## PLANNING CONSULTATION RESPONSE

<b>Application No</b>	2025/0813
<b>Proposal</b>	Erection of single dwelling
<b>Address</b>	Land to the rear of 33 Ballfield Lane, Kexbrough, Barnsley, S75 5LH
<b>Date of Consultation Reply</b>	08/01/2026
<b>Consultee</b>	Katie Lawrence, Planning Ecologist

Figure 3: UkHabs Baseline Habitat Plan

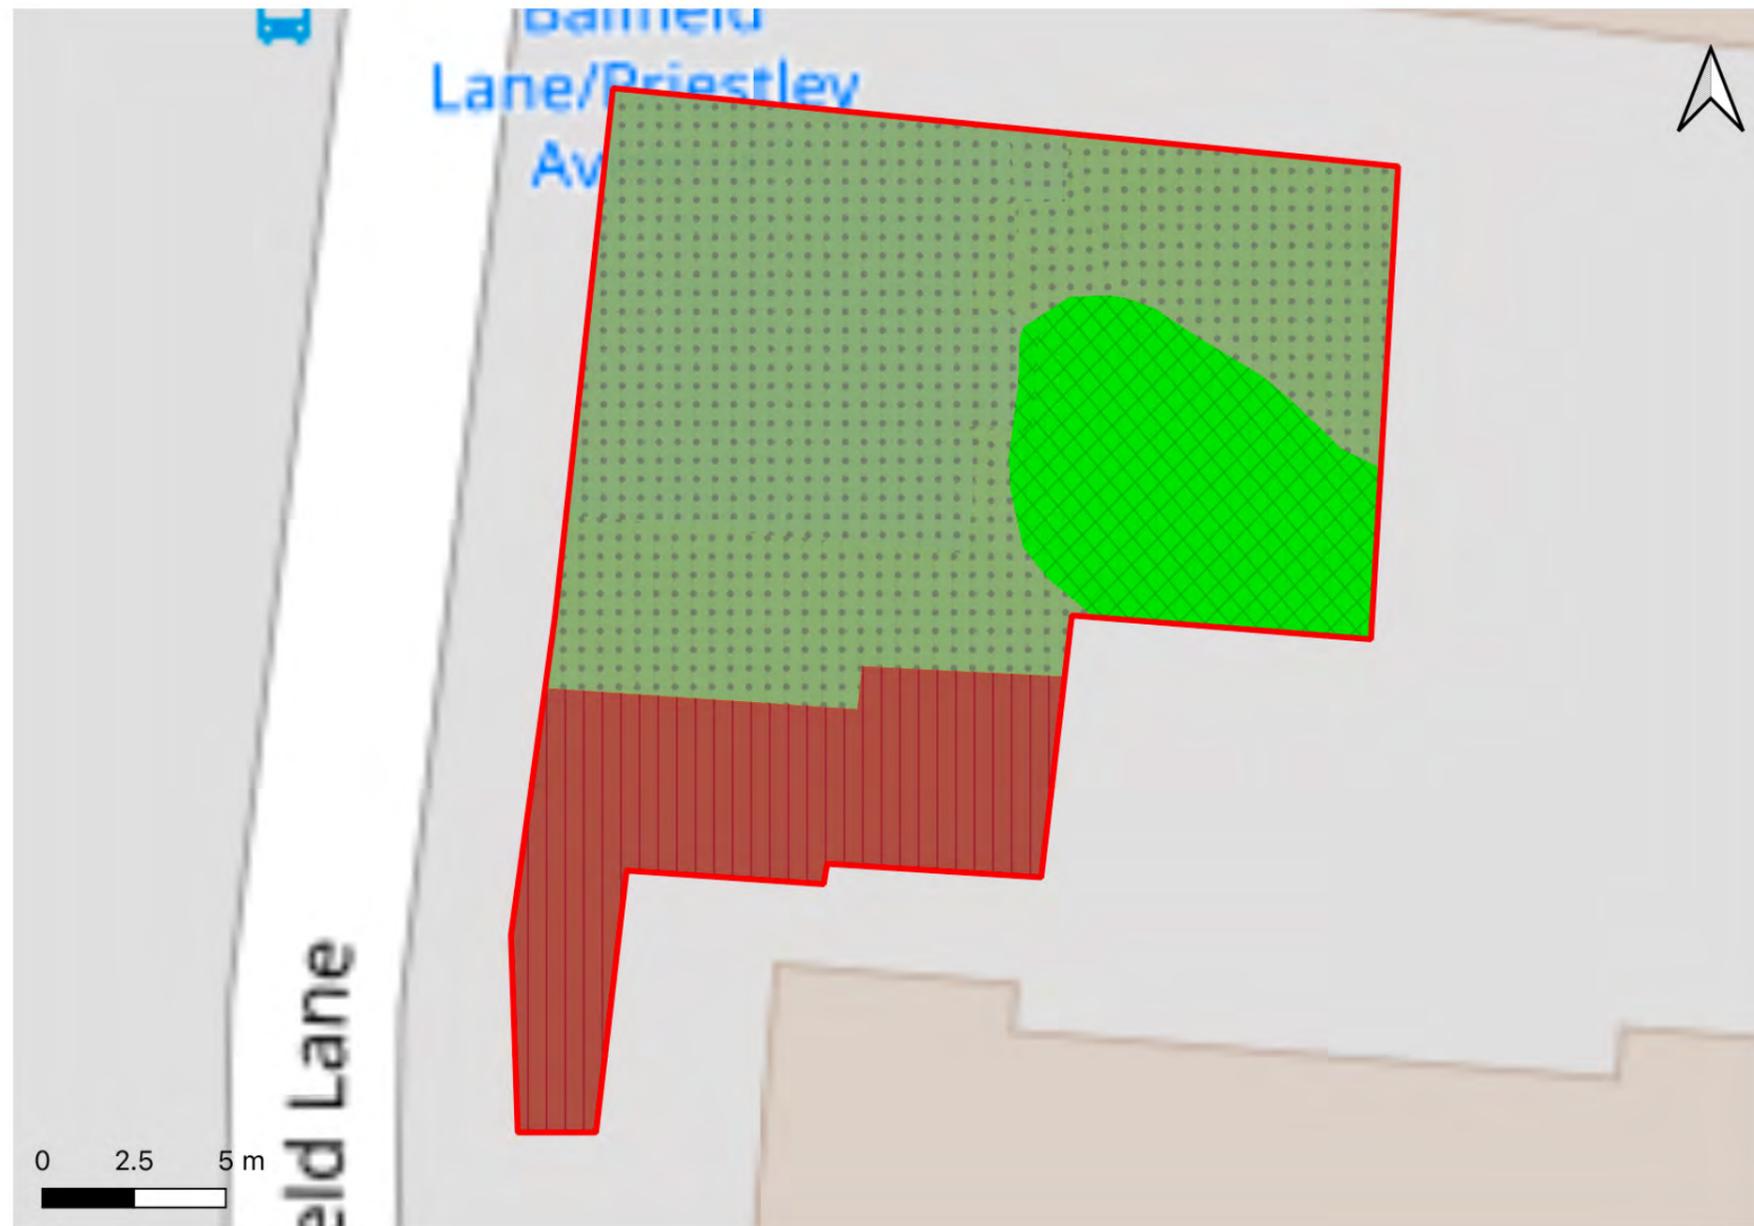
- When referring to aerial photographs of the site it appears as though some clearance works have been undertaken on site. This includes trees and scrub present to the north of property no.1 Copper Road. Trees are visible on aerial photographs dated June 2023, but appear to have been cleared on photographs dated April 2025. When referring to the Biodiversity Net Gain Planning Practice Guidance, it states the following in regards to habitat degradation: Where unauthorised degradation of the onsite habitat has taken place on the land between 30 January 2020 and the date of relevant date (the date of the application), the biodiversity pre-development value of the onsite habitat should be calculated as the biodiversity value of the habitat on the date immediately before the carrying out of these degradation activities. The relevant date should therefore be set as a date immediately before these activities. Unauthorised degradation of onsite habitat is any degradation which is not in accordance with a previous planning permission. The metric and BNG report should be amended accordingly to include for these habitats using a precautionary approach when assigning conditions as per the Statutory Biodiversity Metric Guidance.
